From: Cambridge Waste Water Treatment Plant Relocation
Subject: FW: CWWTPP - Safety on Local Roads - attn Melissa Whitlock for ExA

From: Andy Whitaker <[REDACTED]>
Sent: 20 January 2024 16:43
To: Cambridge Waste Water Treatment Plant Relocation <CambridgeWWTTPR@planninginspectorate.gov.uk>
Subject: Re: CWWTPP - Safety on Local Roads - attn Melissa Whitlock for ExA

# Book of Figures – Traffic and Transport

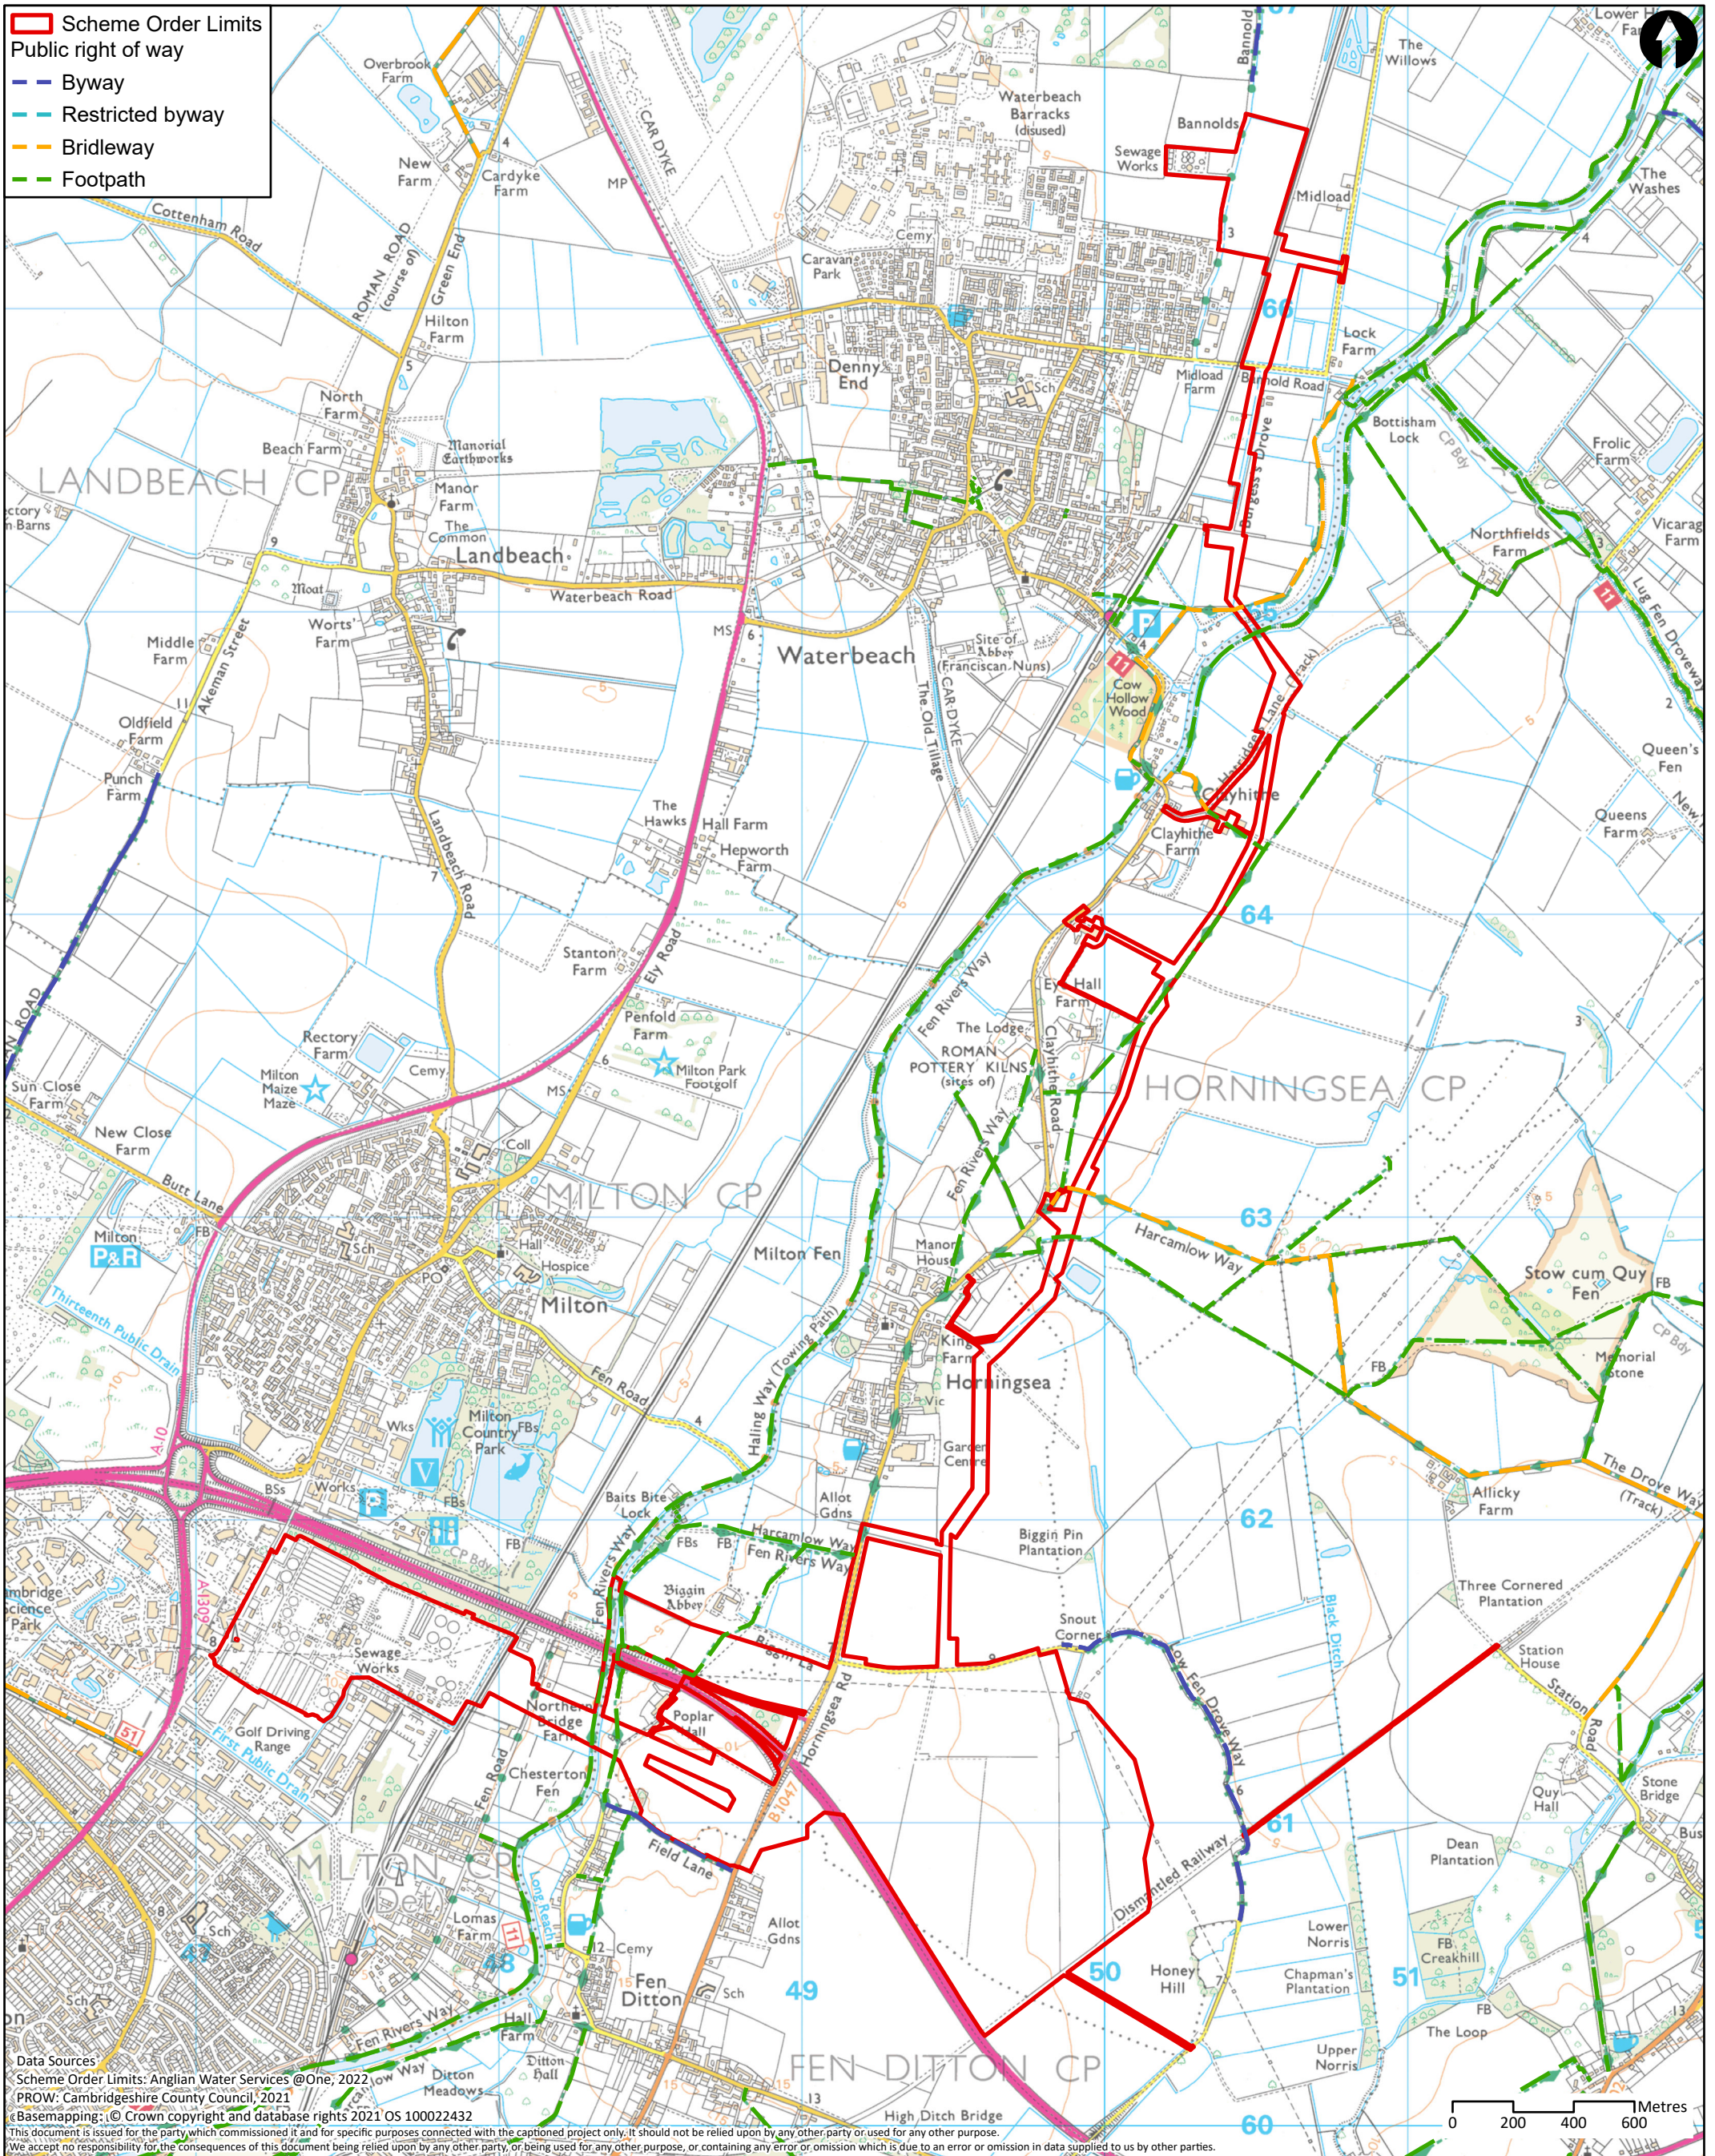
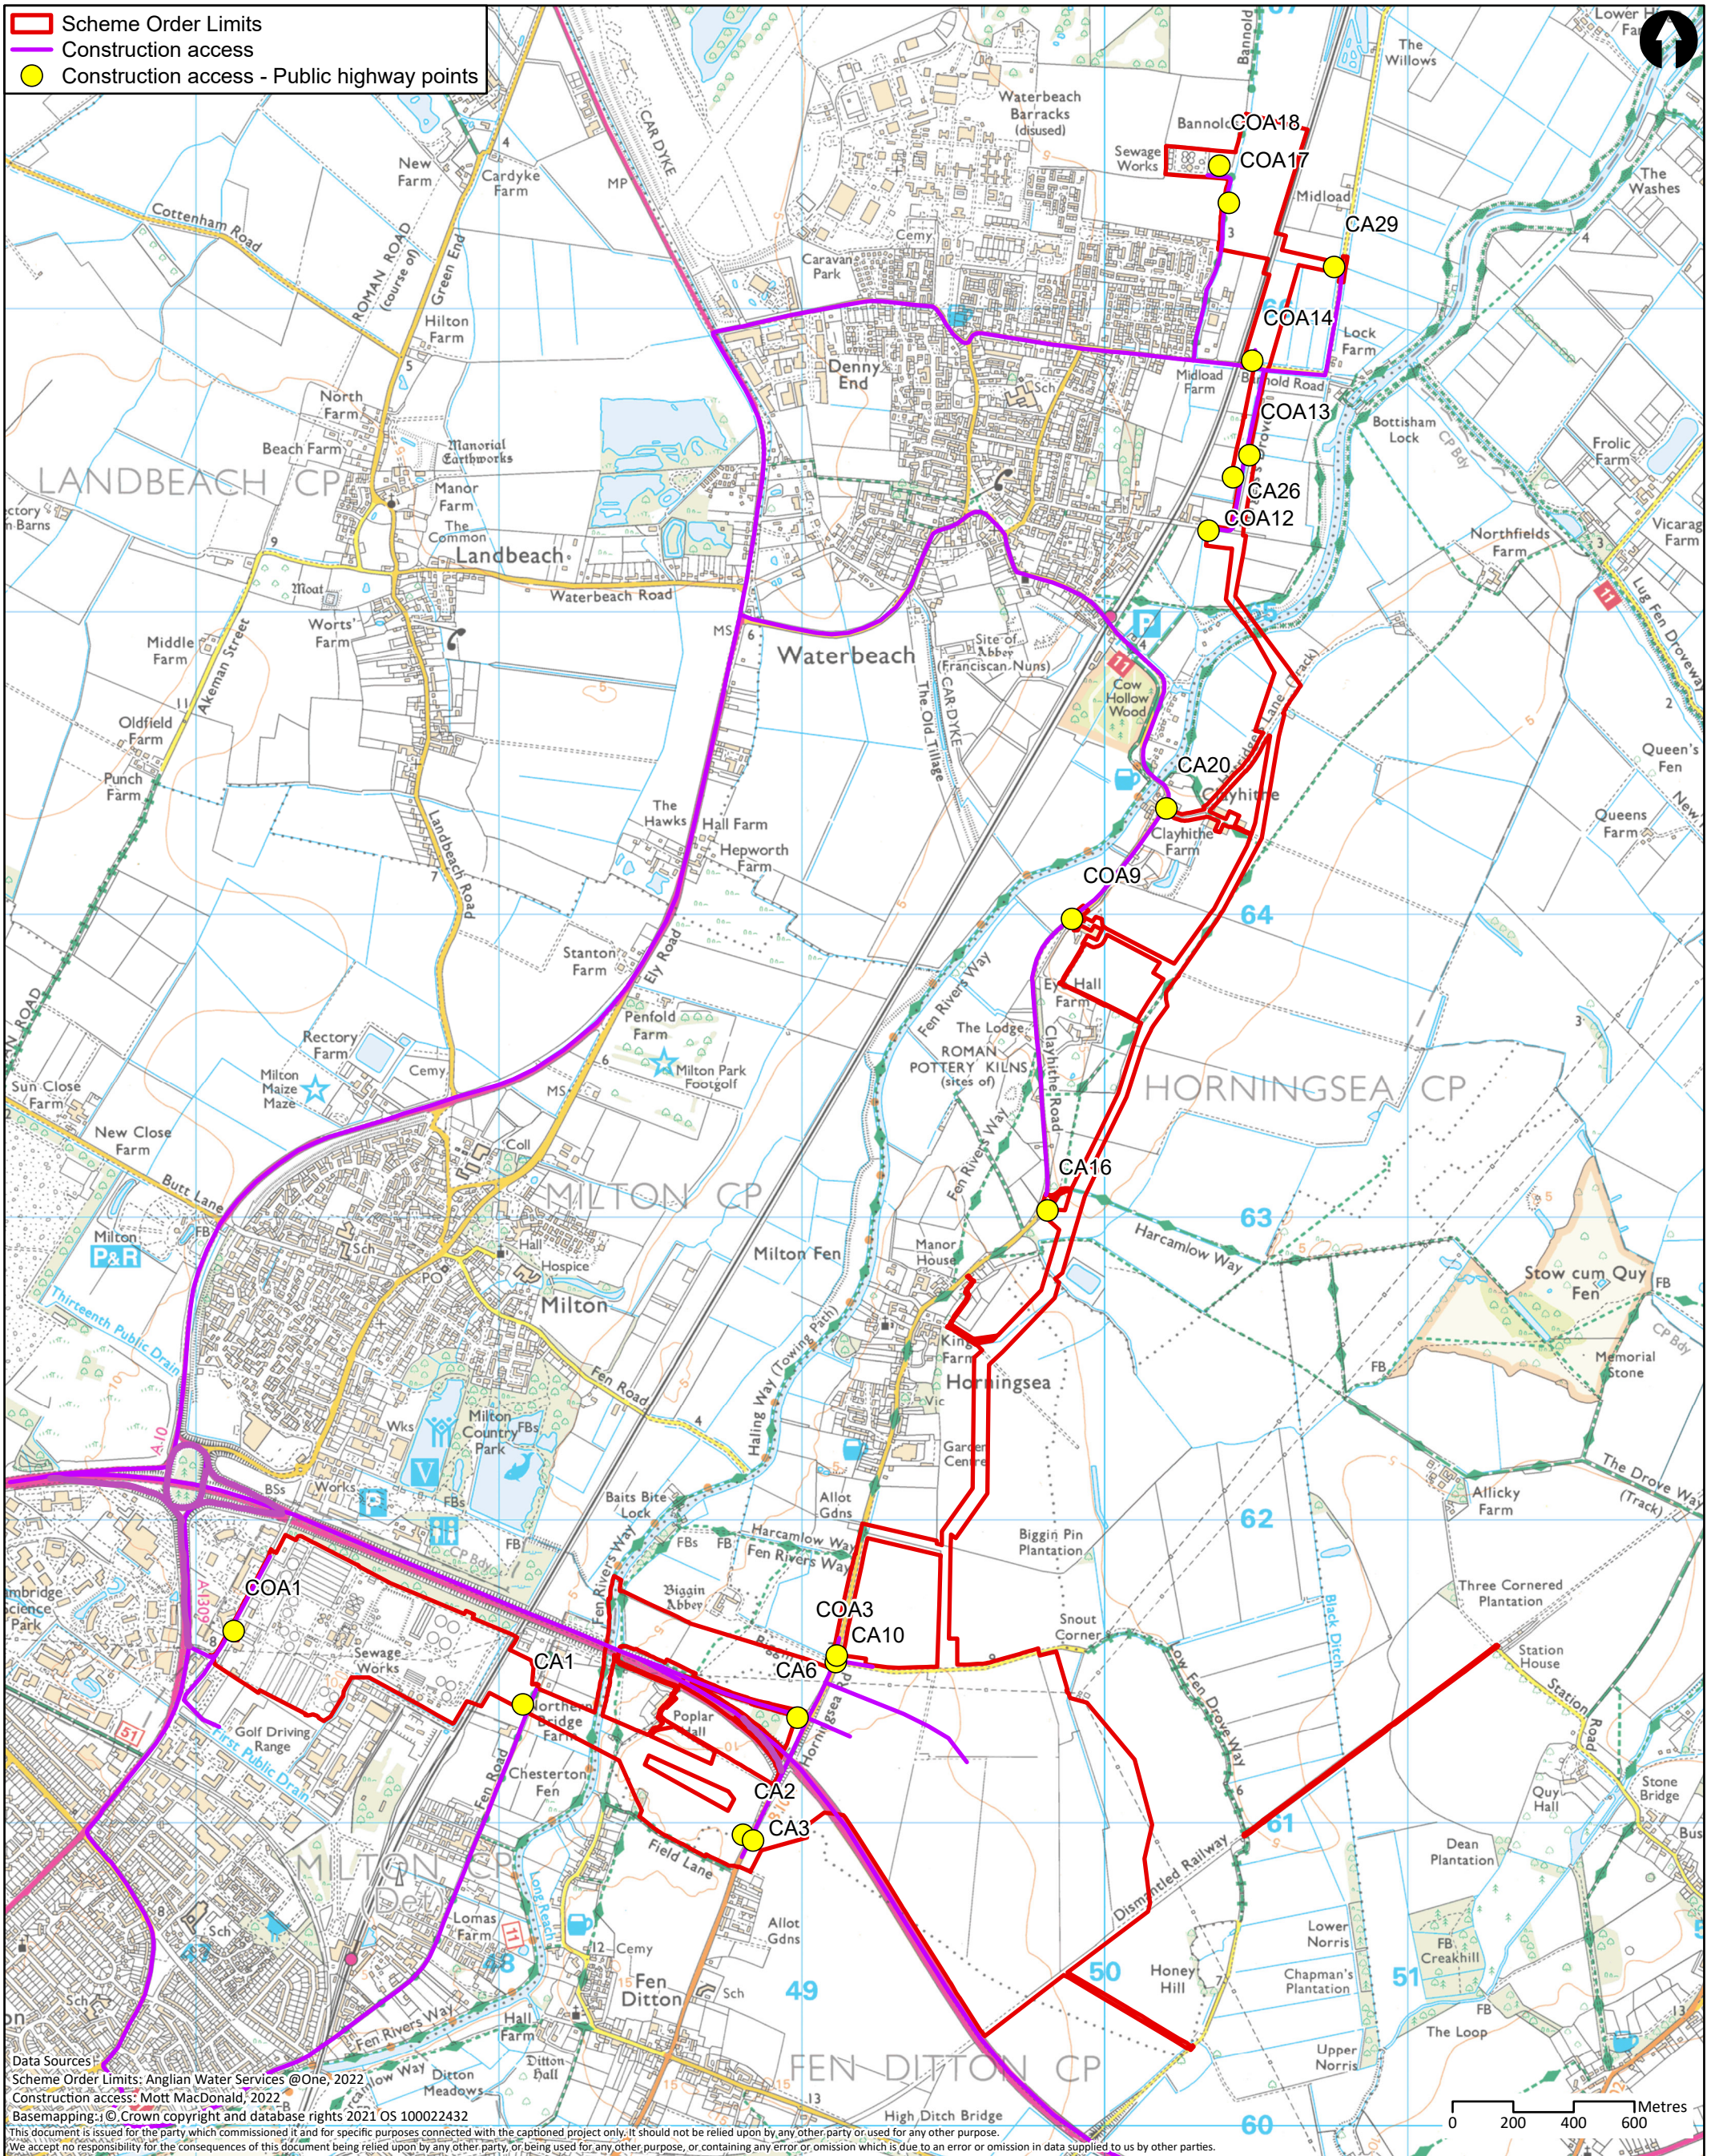
I conclude that the revised Traffic Plan still does not support the previous assurances by the Applicant on traffic prohibition on local roads, especially High Ditch Road. This is necessary to protect vulnerable users such as cyclists, pedestrians and horse riders during the construction and operation phases. More such users are expected to use High Ditch Road through the local amenity development schemes.

1. ANPR is required on High Ditch Road to provide minimum safety assurance. Signage is not enough. After years of discussions an agreement should have been reached between the Applicant and Highways on this - after all an ANPR system for the whole of Cambridge is proposed for the Cambridge Travel Zone. Site access control by listed vehicle registration is used widely.

2. All contractors must be included in the ANPR control measures, not just "main" contractors.
3. The Public Liaison reporting scheme proposed is no substitute for a proper ANPR control. A cyclist at the narrow hump-back bridge on High Ditch Road will not know if a truck is heading for the CWWTP site, and would have more concerns than trying to read vehicle details, let alone asking the driver if they are going to CWWTP. So, a reporting scheme may be supplementary but is completely inadequate for safety.

4. The cause of these safety issues is the poor road access to the chosen CWWTP site. The Application may say that CWWTP construction traffic and operation traffic will not use High Ditch Road, Ditton Lane (B1047), Newmarket Road A1303 from Quy, and J35 A14 Quy - but the lack of access to and from the east at J34 means this traffic will be tempted to use J35 and High Ditch Road to avoid the proposed ridiculous round trip to J33 Milton and back. Under ExA's "*Action points arising from Issue Specific Hearing 3 on 10 and 11 January 2024 Transport 7*" it is probable that National Highways' analyses of J33 and J35 will conclude these junctions are already overloaded at many times. During the Consultations the Applicant said National Highways had said no to development of J34 to a full interchange. However, (notwithstanding the other objections to the site), it is not clear if ExA is aware of, or National Highways were asked to consider, alternative schemes with access limited to works only traffic such as that below, suggested to the Applicant in the 2021 Consultation.
